## WEST SUSSEX COUNTY COUNCIL CONSULTATION

| <b>LOCATION:</b>                | Cinders Lane Nursery And Works To The Rear<br>Cinders Lane<br>Yapton<br>BN18 0JJ                                                                                                                                          |
| <b>SUBJECT:</b>                 | Y/48/19/DOC<br><br>Approval of details reserved by condition imposed under Y/5/17/OUT relating to Condition Nos 9 - Construction Management Plan and 10 - contamination of the site.<br><br><b>Revised plan received.</b> |

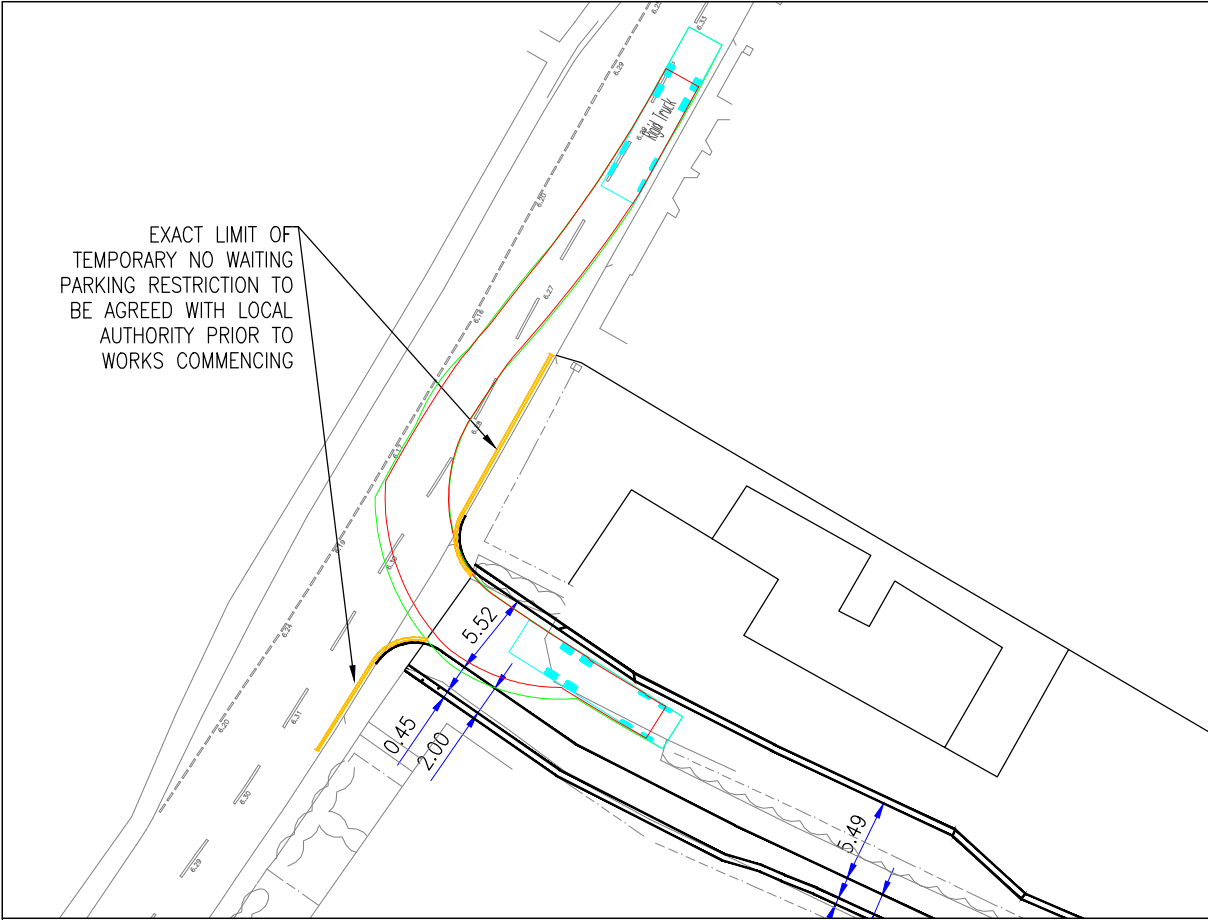
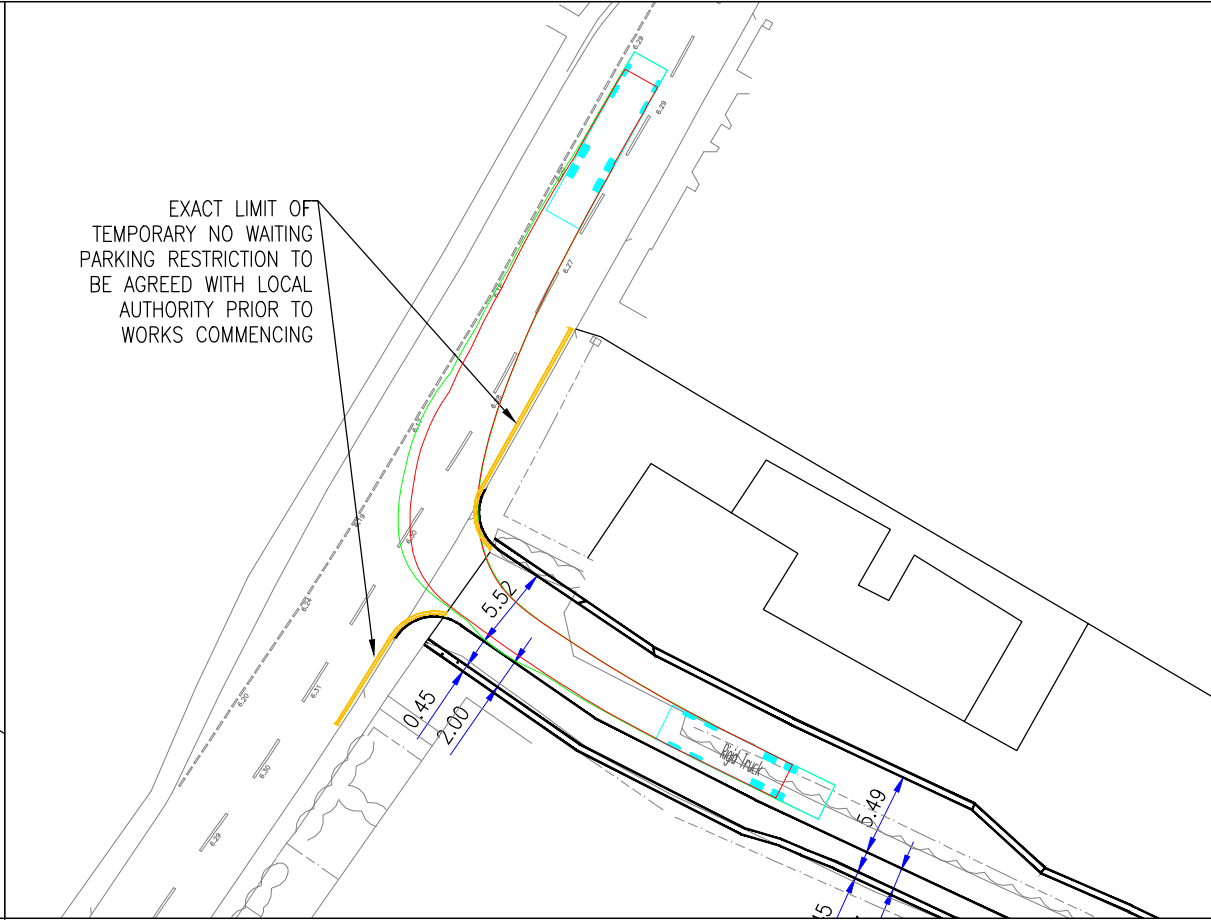
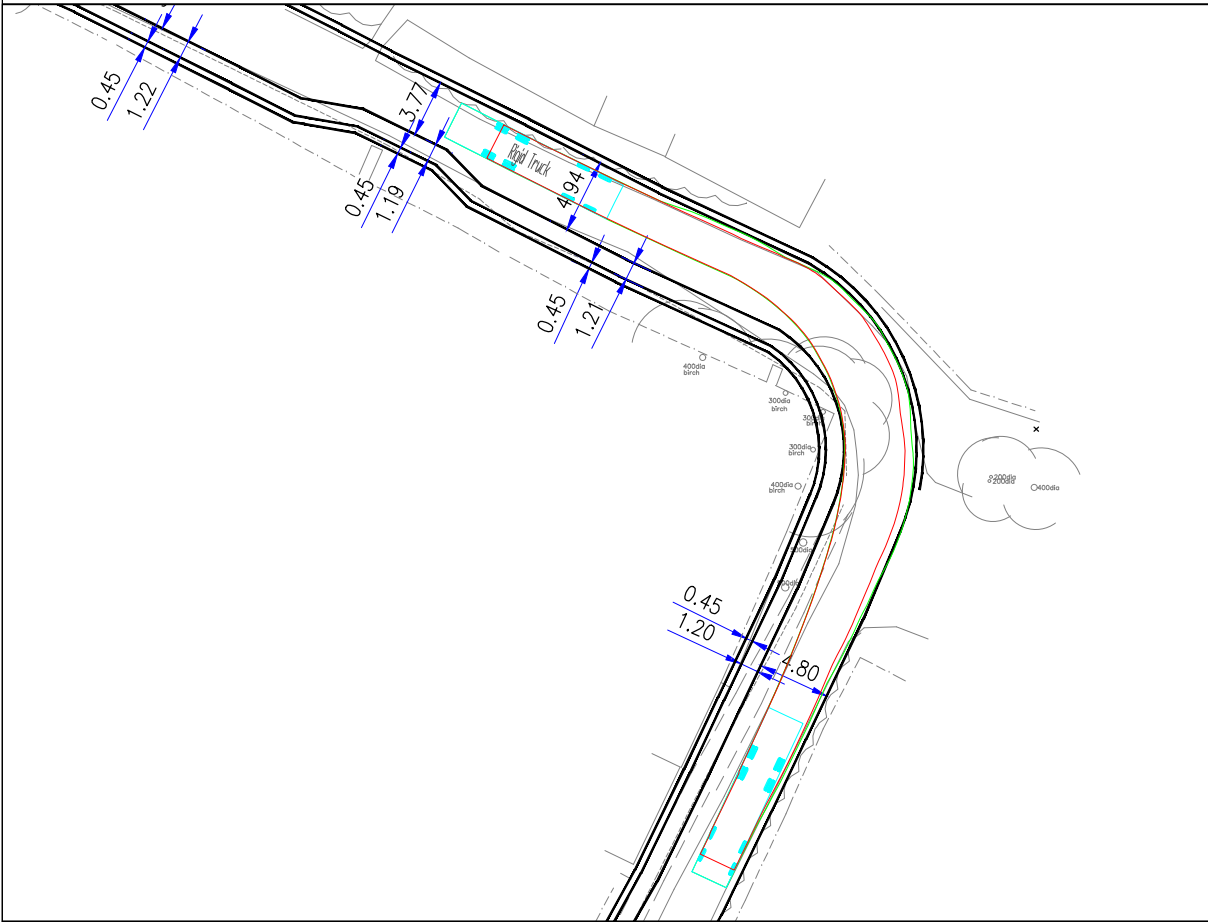
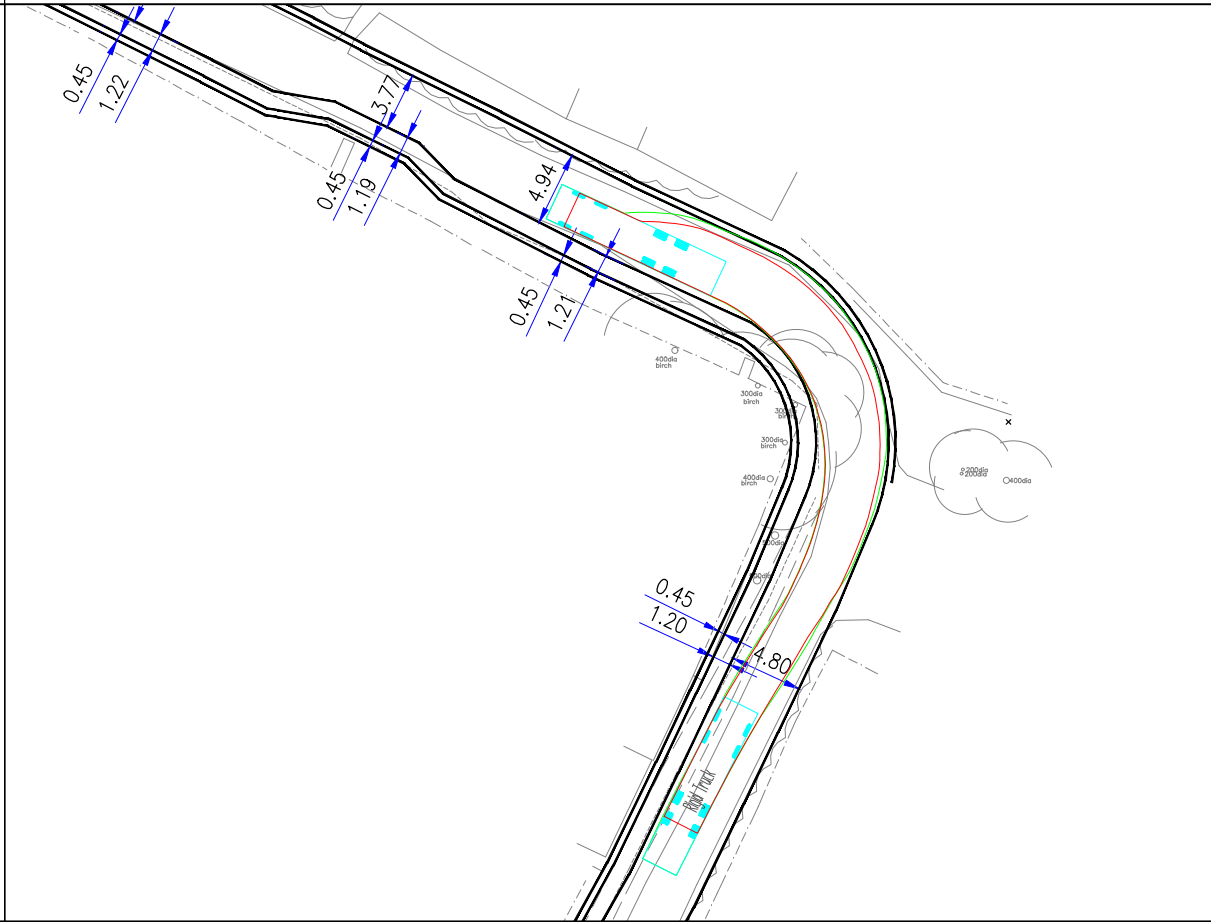
2. The location of the site gates should be shown on the plan. *Shown on 'Site Wide Elements Plan' numbered 19.14.102.D.*
3. Swept-path diagrams should be provided at the junction of Cinders Lane with Bilsham Road showing the tracking for the different types of construction vehicles entering and leaving the site. They are required in order to inform any temporary traffic management measures and/or temporary Traffic Regulation Orders that might be needed throughout the course of construction to minimise disruption when vehicles (particularly large ones) are attempting to enter and leave the site. *Only large rigid vehicle shown on the tracking diagram drawing No. 020.0096.013. The applicant has stated in email of 8th July 2019 (Matthew Utting to Simon Davis) that no articulated vehicles will be required for the construction phase. However, based on that shown, it is the view of the CHA that a Temporary Traffic Regulation Order (TTRO) will be required in an attempt to prevent vehicles parking on the carriageway of Bilsham Road and obstructing traffic movements in proximity to the site access throughout the construction phase. As such, the applicant - prior to commencing works - must contact WSCC Highways to apply for the TTRO. Full details can be found on the WSCC website.*

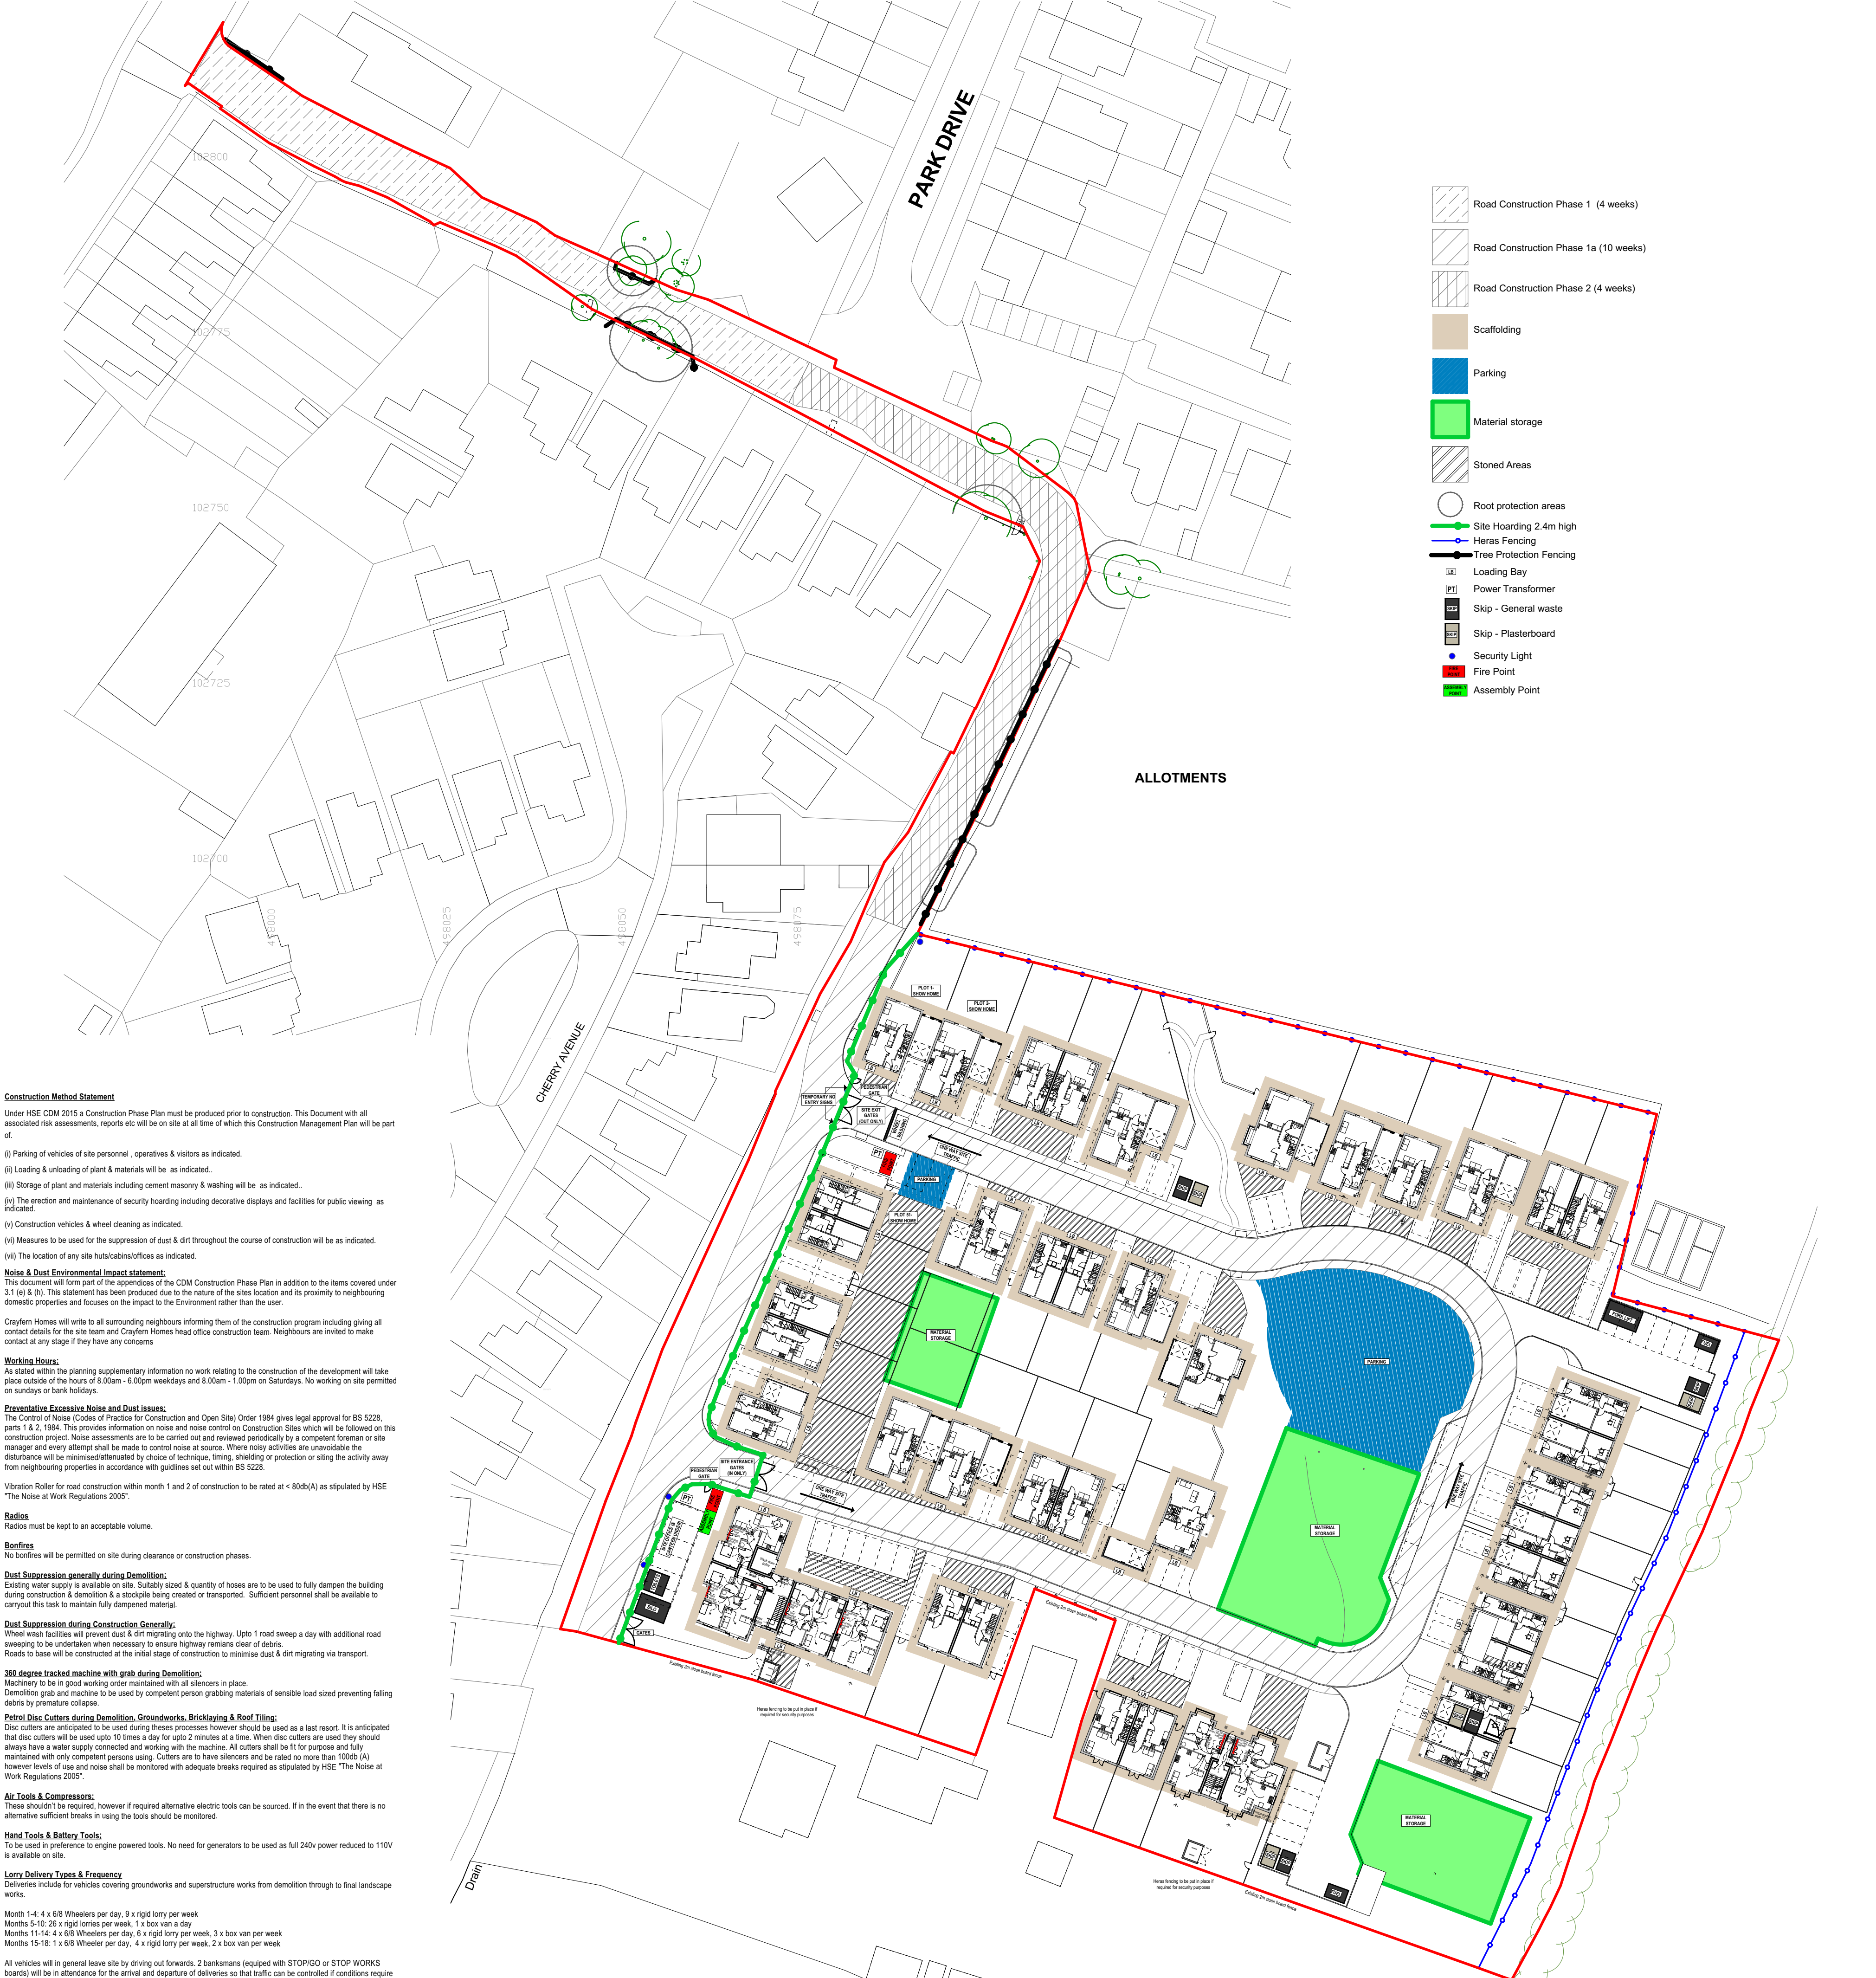
1. Confirmation that out-of-hours contact details will be made available on site hoardings, gates and to local residents. *Confirmed on 'Site Wide Elements Plan' numbered 19.14.102.D (as 'emergency contact details').*
